Please ask for: Sian Eggington
Email: sian.eggington@terraquest.co.uk
Telephone: 0121 234 1390
Our Ref: WA/114/21/HH
Your Ref:
Date: 18th January 2022

Application for Planning Permission for Works or Extension to a Dwelling

Development: Proposed rear single storey extension
Location: 27 Oaktree Cottages Barnham Lane Walberton BN18 0AY

Location Plan shows area bounded by: 496333.77, 105810.67, 496475.19, 105952.09 (at a scale of 1:1250), OSGridRef: SU9640 588. The representation of a road, track or path is no evidence of a right of way. The representation of features as lines is no evidence of a property boundary.

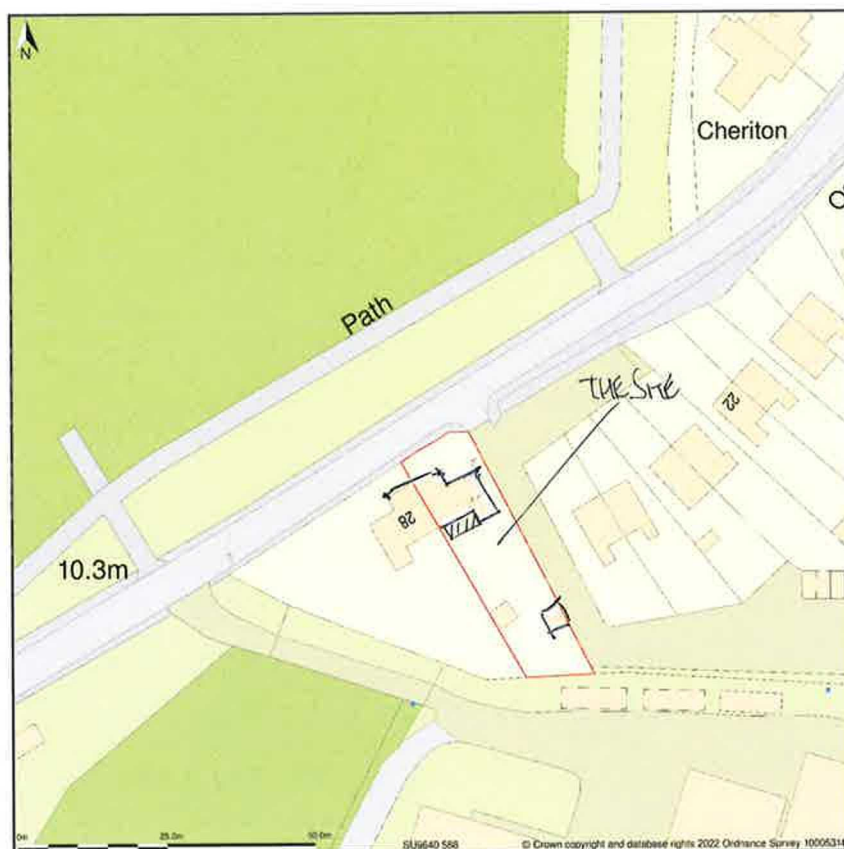
The location plan requires one solid outline around the site boundary. The current plan has 2 outlines, please amend. Further details of what must be included on the plan can be found in the Validation Requirements List.
